PROJECT NAME: **White Water PBCP (LP-08-28)**

KITTITAS COUNTY LAND USE HEARING EXAMINER

<p>IN THE MATTER OF) LP-08-00028) White Water Performance Based Cluster) Plat)</p>	<p>RECOMMENDED FINDINGS OF FACT, CONCLUSIONS OF LAW, DECISION AND CONDITIONS OF APPROVAL</p>
--	---

DWN BY DATE 07/08 JOB NO. 08068
 CHKD BY G. WEISER SCALE 1"=200' SHEET 2 OF 4
 D. NELSON

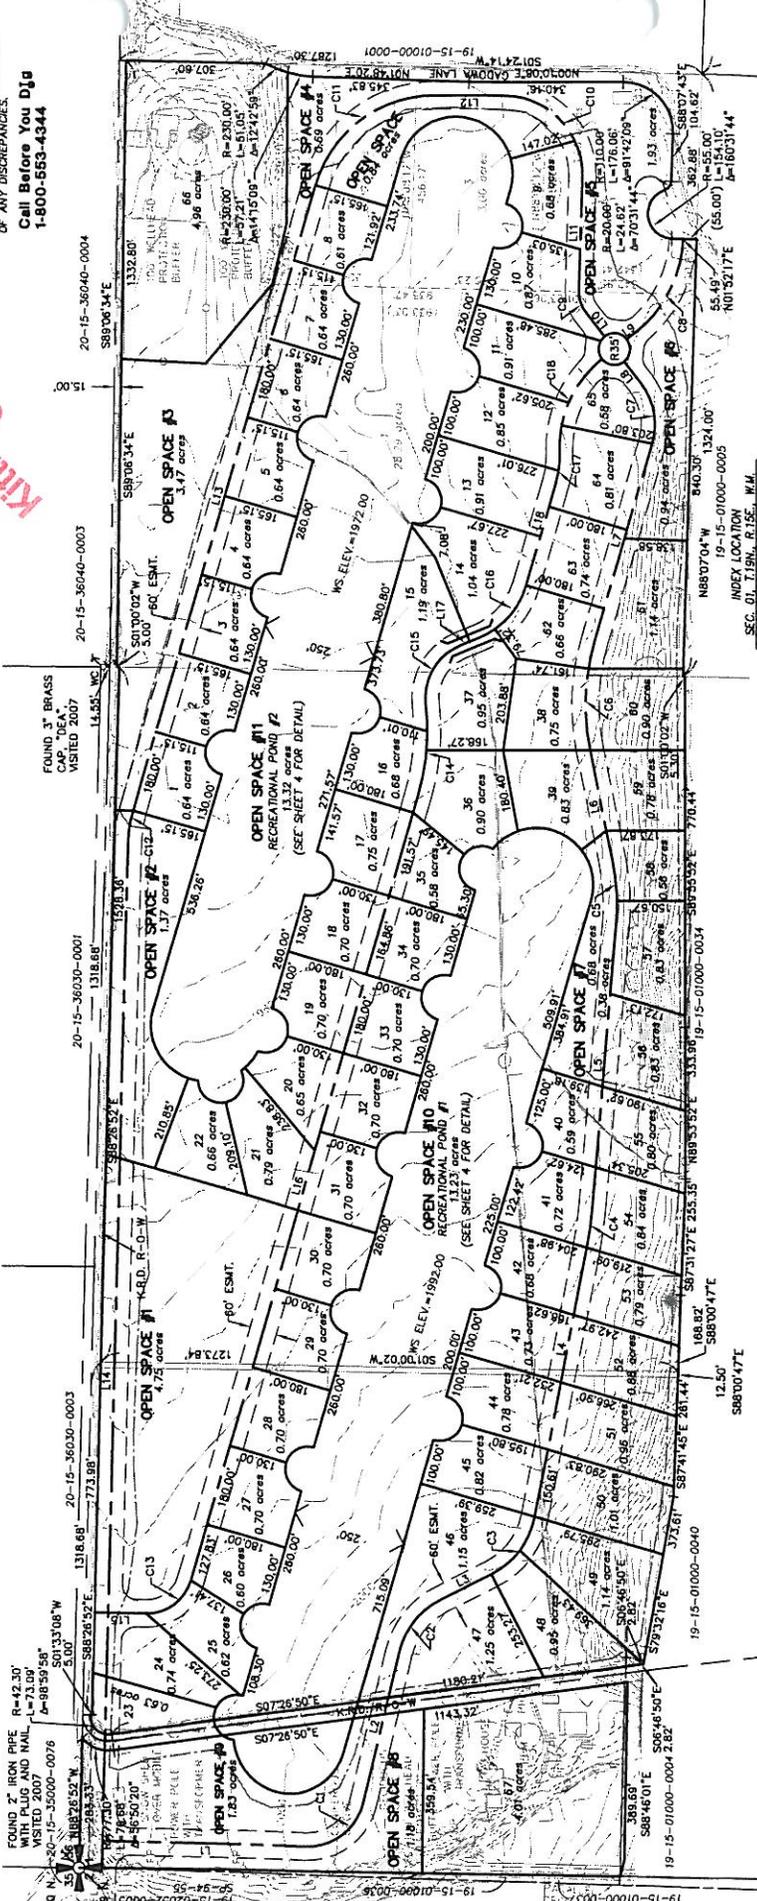
17. Lot 24: Access shall be provided to Lot 24.
18. Godawa Lane Spelling: Godawa Lane shall be spelled correctly on all documents. It is currently spelled incorrectly on Sheet 2 of the plat.
